# Charlotte Department of Transportation

## Memorandum

**Subject:** Rezoning Petition 08-074: Located on the north side of Hickory Grove Road between Dogwood Place and Lawrence Orr Road

PRELIMINARY
SITE PLAN

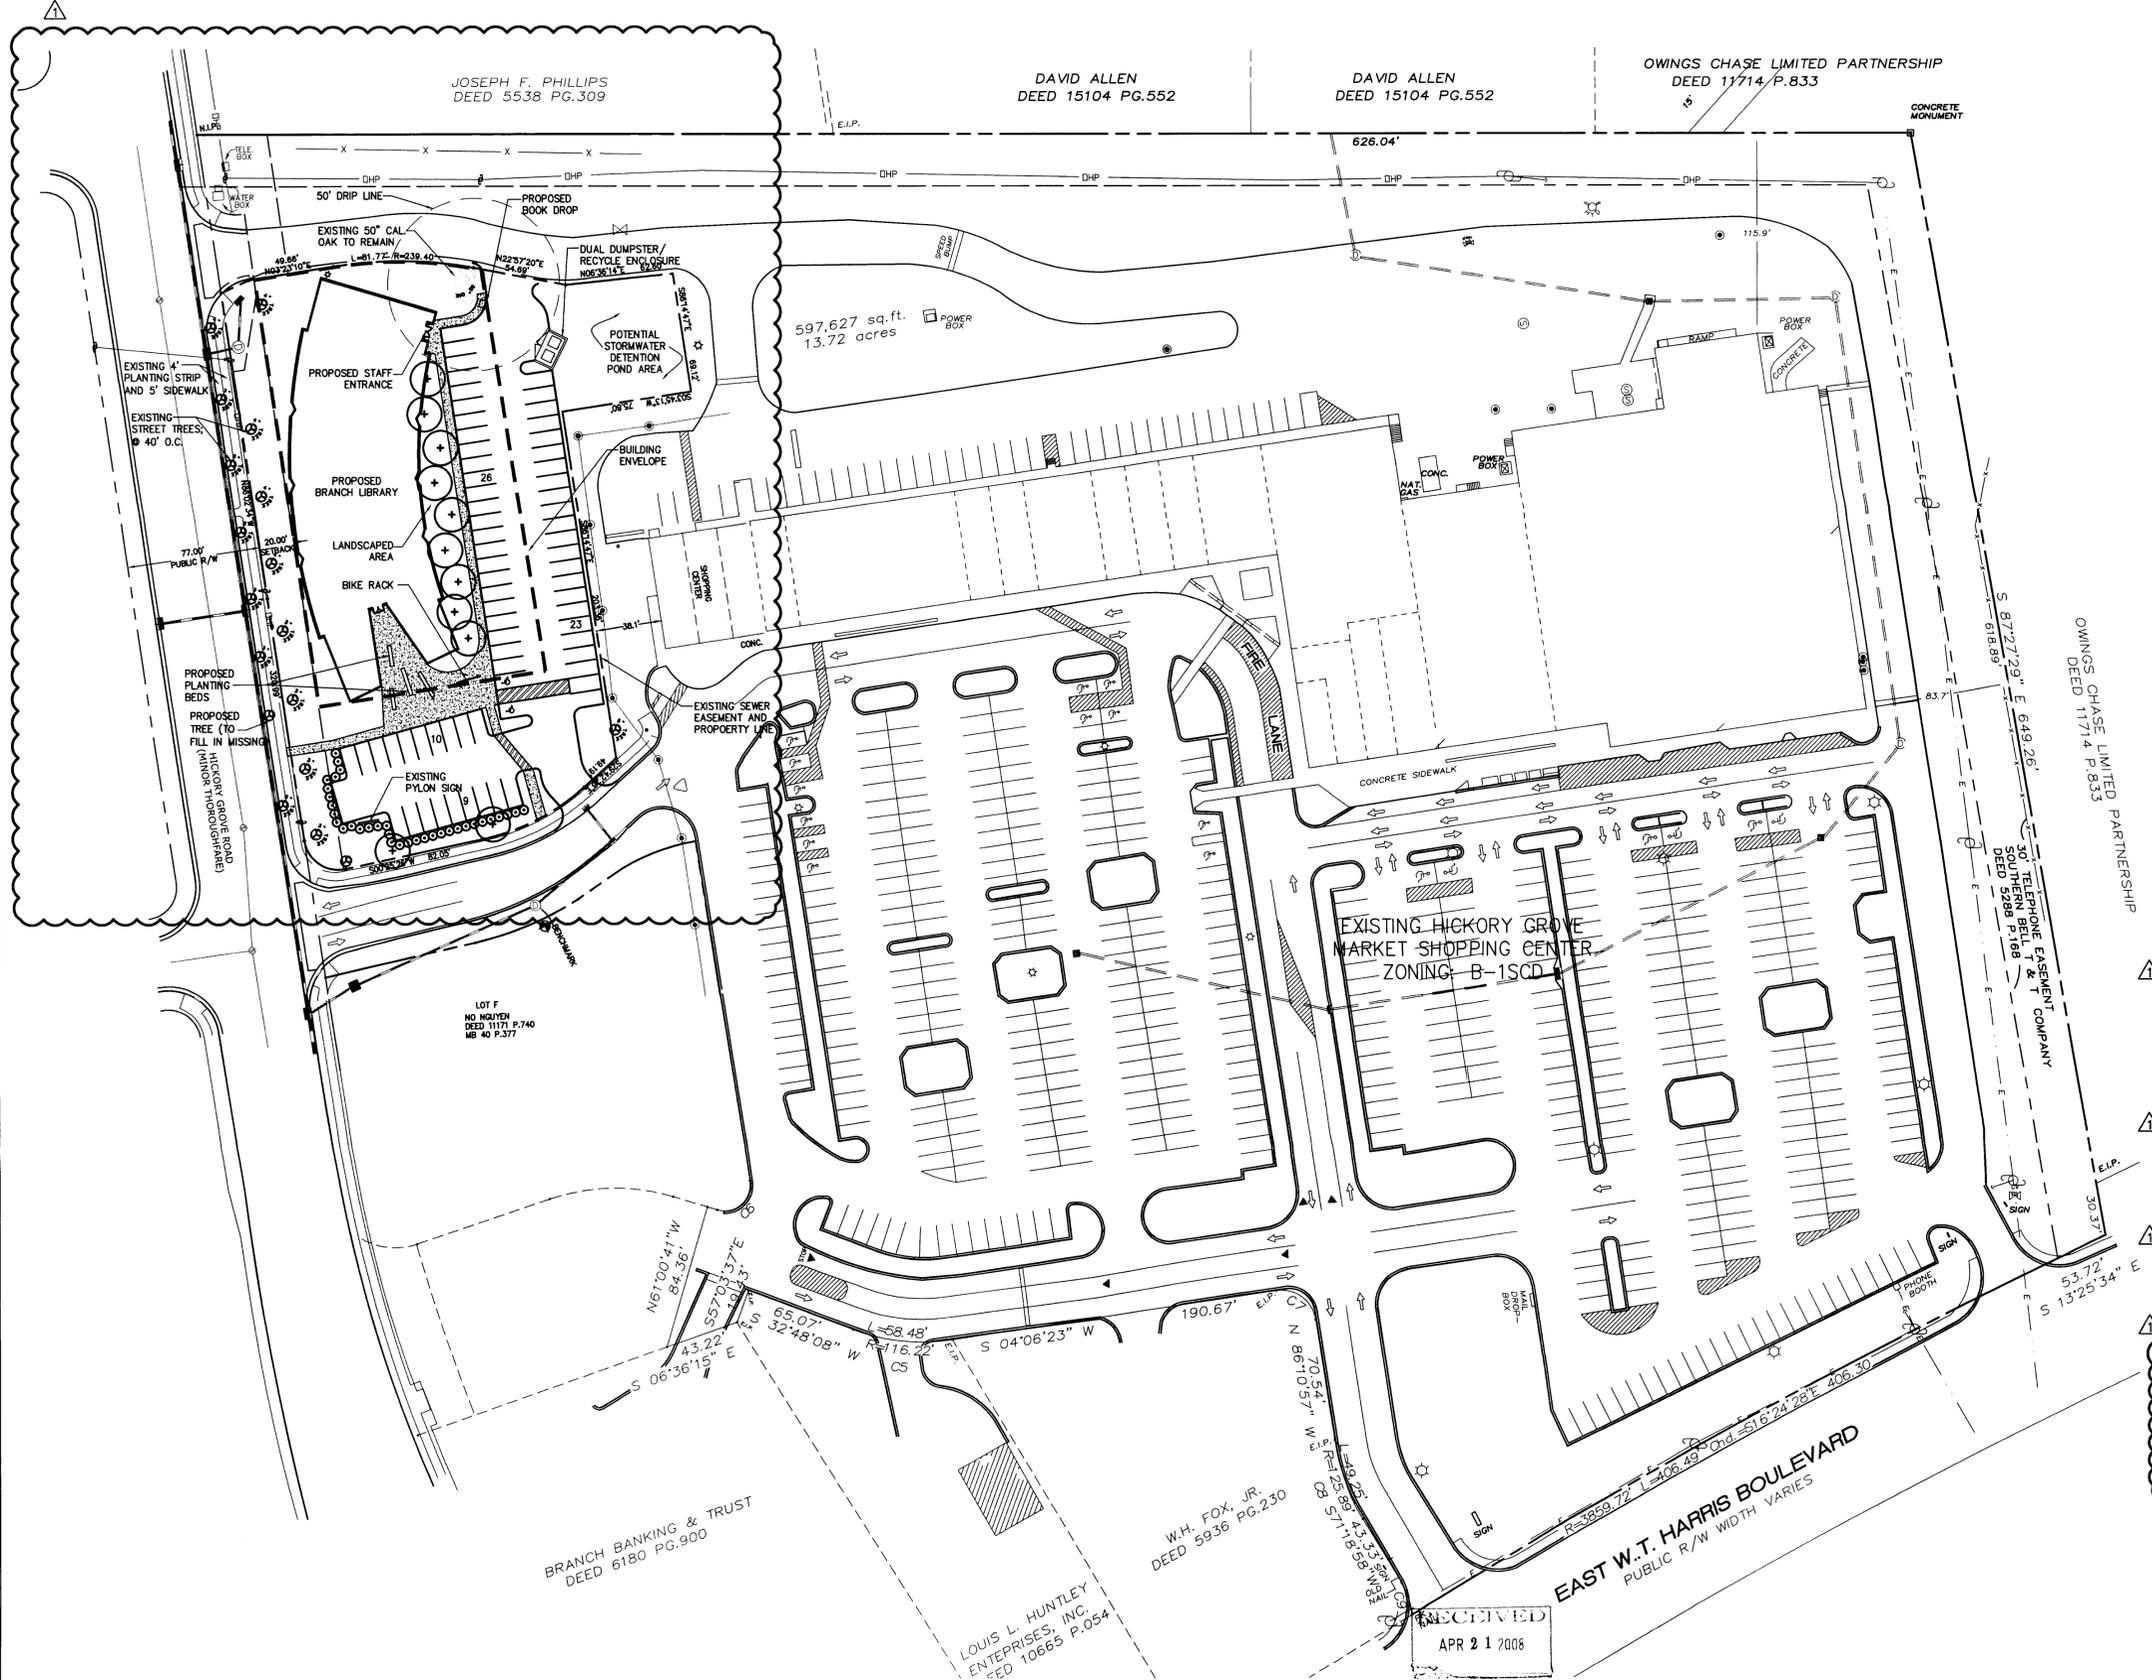
1. As it is shown on the plan, unless the waste collection vehicle is side-loaded, the dumpster cannot be easily accessed. The dumpster location needs to be based on the type of waste collection pick-up/delivery system. A location/design that accommodates both a front and side-loading system is desirable for maximum flexibility. The dumpster location and maneuvering path for the waste collection vehicle needs to be shown on the site plan.
2. The proximity of the internal driveway from the site to the main entrance driveway and adjacent aisle intersection cannot be approved as shown because it does not facilitate safe circulation. This location needs to be moved or consolidated with the access to the north.

3. The site plan does not show a book drop for the library. If the library will be using a stand-alone drop box, the location needs to be shown on the plan. The drop box cannot affect parked vehicles or impede traffic flow through the site.
4. The existing shopping center sign needs to be shown on the plan. It appears that the location of this sign may impact the proposed parking.

1. The site plan needs to extend the existing internal sidewalk shown adjacent to the parking lot nearest the primary entrance to the existing sidewalk along Hickory Grove Road, which is also a bus route.

Hickory Grove Road is a minor thoroughfare requiring a minimum of 70 feet of right-of-way. The developer/petitioner should convey right-of-way in fee simple title to meet this requirement, measuring 35 feet from the centerline of the roadway.

Adequate sight triangles must be reserved at the existing street entrances. Two 35-foot x 35-foot sight triangles are required to meet requirements. All proposed trees, berms, walls, fences, and/or identification signs must not interfere with sight distance at the entrances. Such items should be identified on the site plan.

- All City of Charlotte Land Development Standards (latest revision) will apply.
- Dimension width of the existing and proposed driveways.
- New/reconstructed driveways must be drop curb ramp Type II-Modified driveways.

- Indicate the locations and widths of all adjacent and opposing driveways.
- Indicate typical parking module dimensions.
- Directional wheelchair ramps (two per corner) should be provided at all intersections of public and private streets.
